East Anglia ONE North and East Anglia TWO Offshore Windfarms

Applicants' Comments on Historic England's Deadline 4 Submissions

Applicant: East Anglia TWO and East Anglia ONE North Limited
Document Reference: ExA.AS-7.D5.V1
SPR Reference: EA1N_EA2-DWF-ENV-REP-IBR-001221

Date: 3rd February 2021
Revision: Version 1
Author: Royal HaskoningDHV

**Figure 29.21 Update Viewpoint 9:  
B1121 Aldeburgh Road (south of  
Friston)**

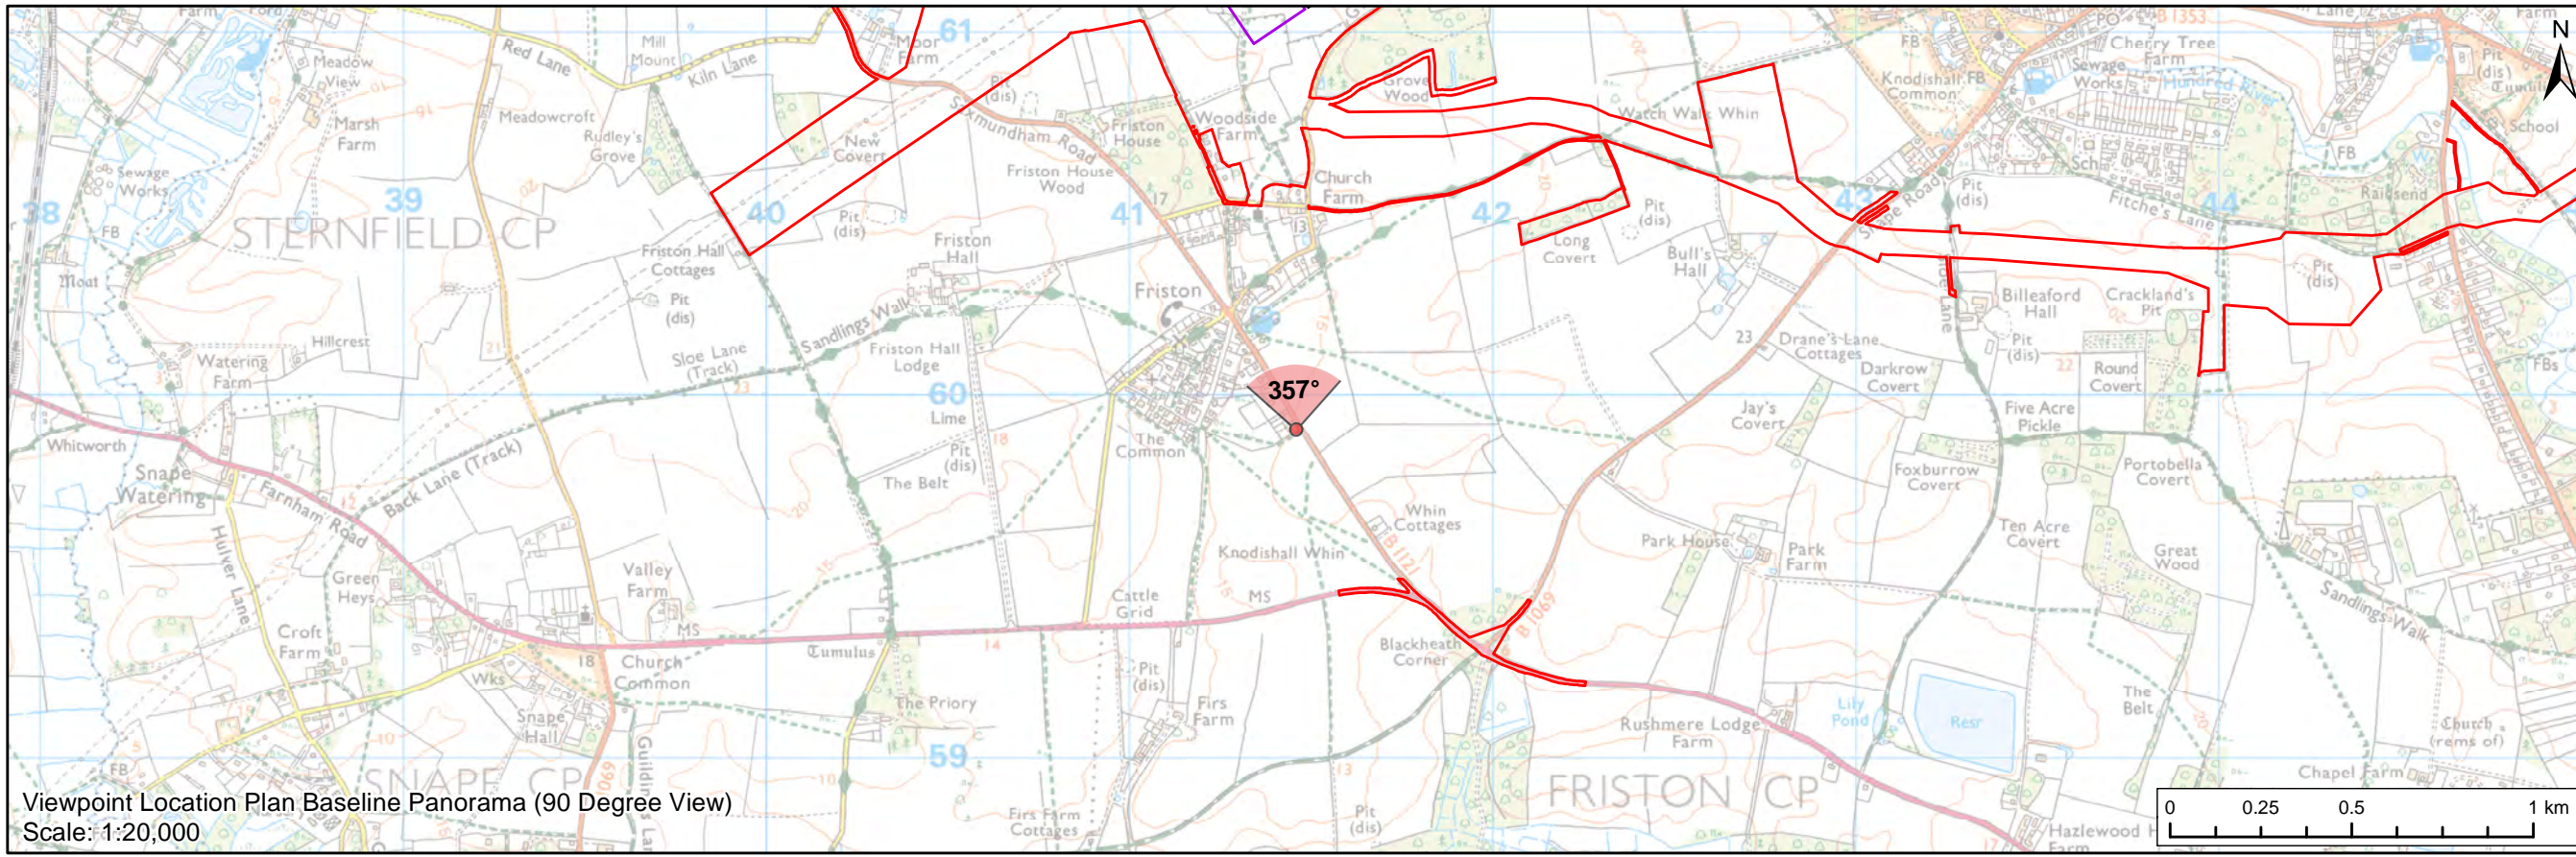
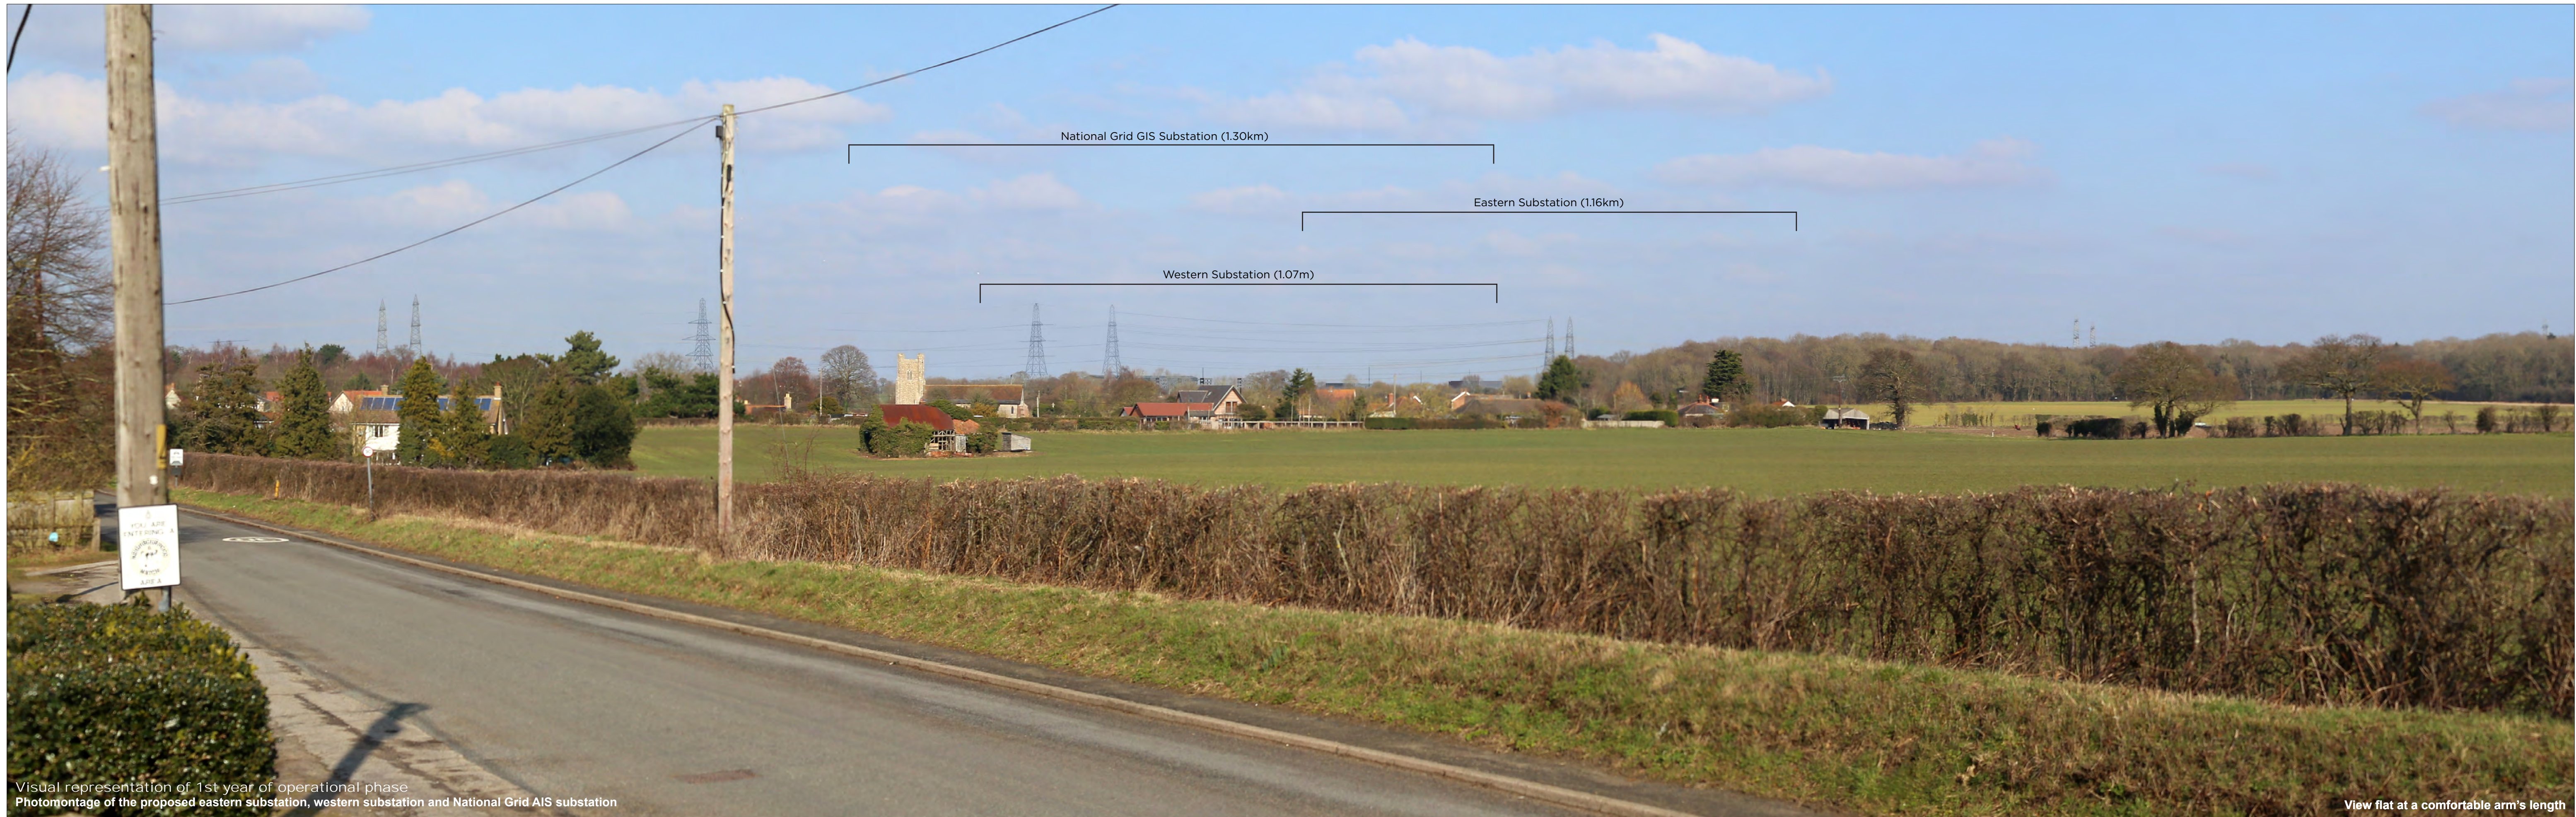
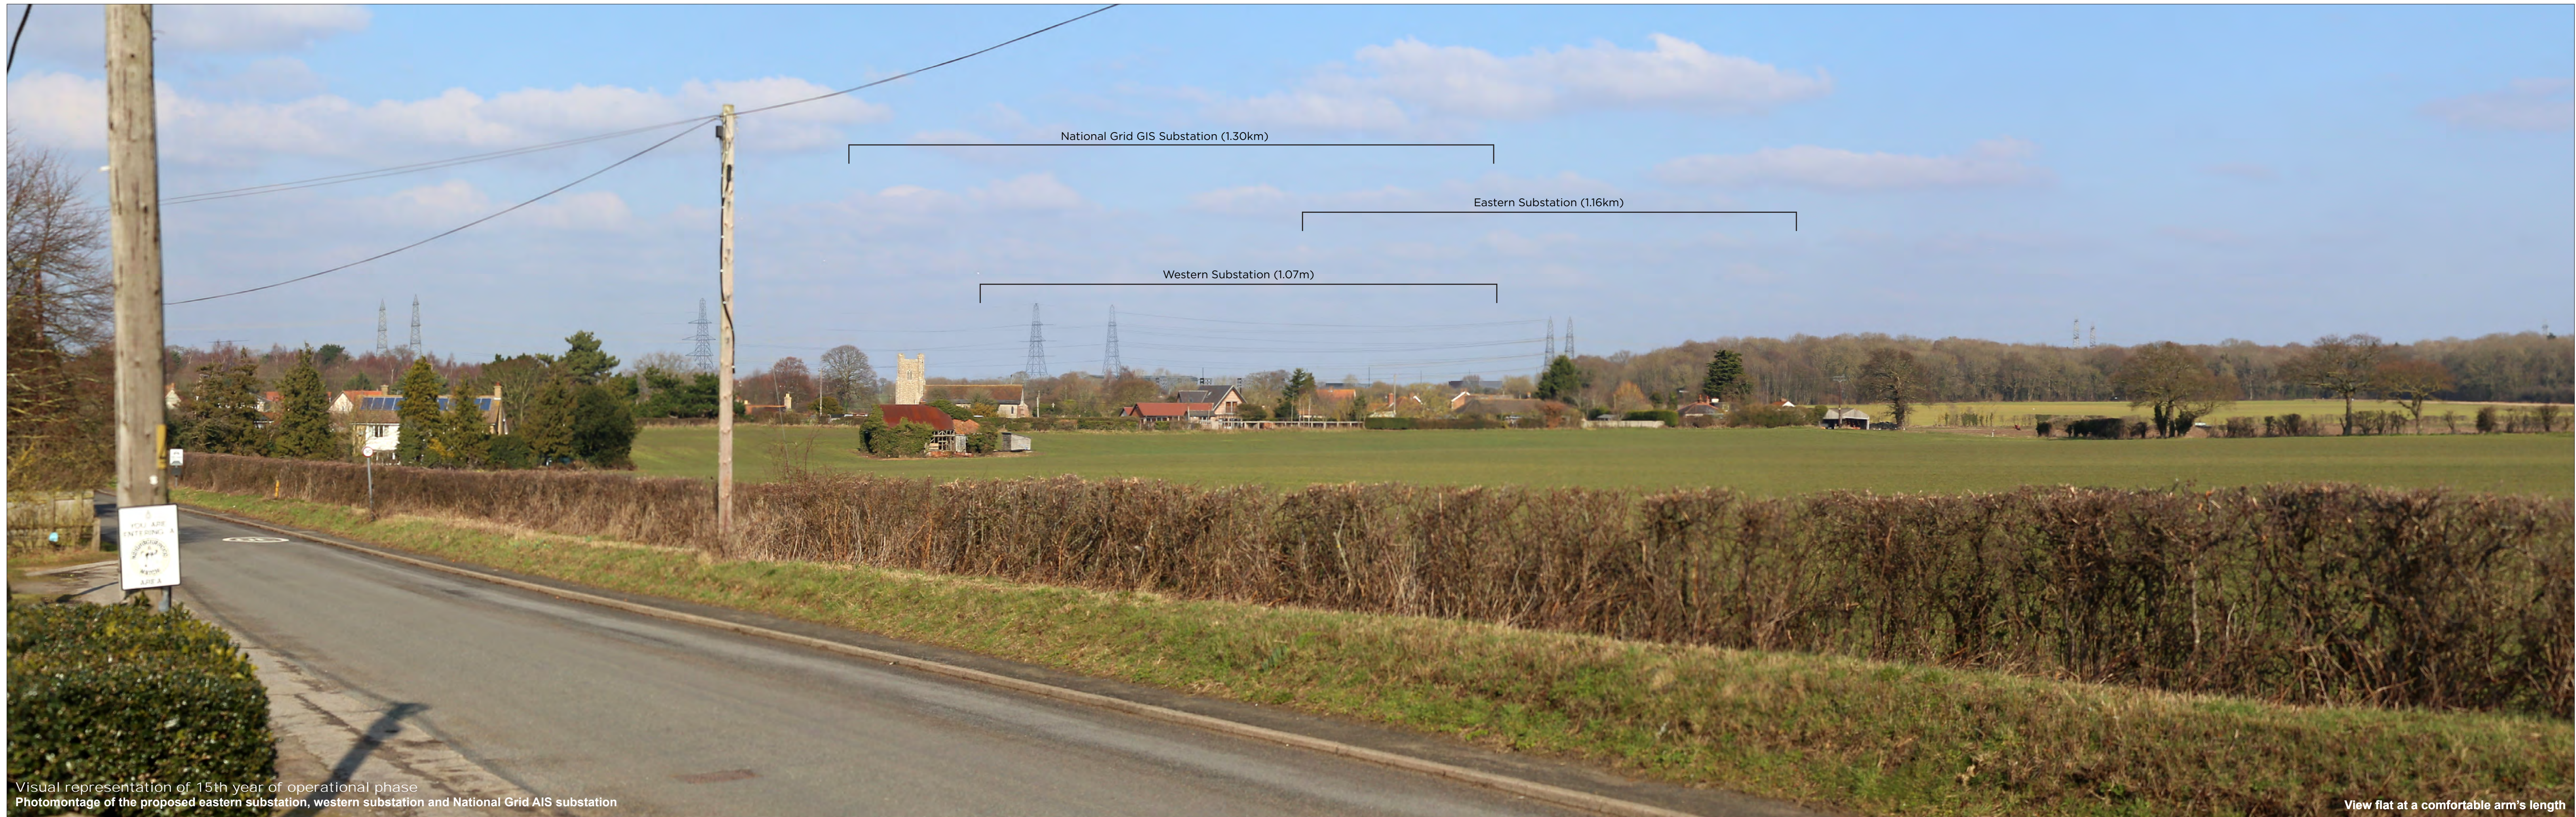
008	<p>That said, viewpoint 9 perhaps illustrates best that there will be some reduction in overall visibility of the scheme in longer range views particularly from the south of the village and that these changes would result in a lessening of the overall visual impact.</p>	Noted. The Applicants welcome this position.
009	<p>Views of the church from the north will still however be obliterated as illustrated (CHVP4), and in spite of the changes the loss of the footpath will continue to lead to a change to the relationship between the church and this land to the north. We not feel it is necessary to repeat the case we have presented with regards to the important contribution this area of</p>	<p>The Applicants refer HE to the Heritage Assessment Addendum and Appendices (REP4-006 – REP4-012), which provide an update of the assessment in light of these changes.</p>
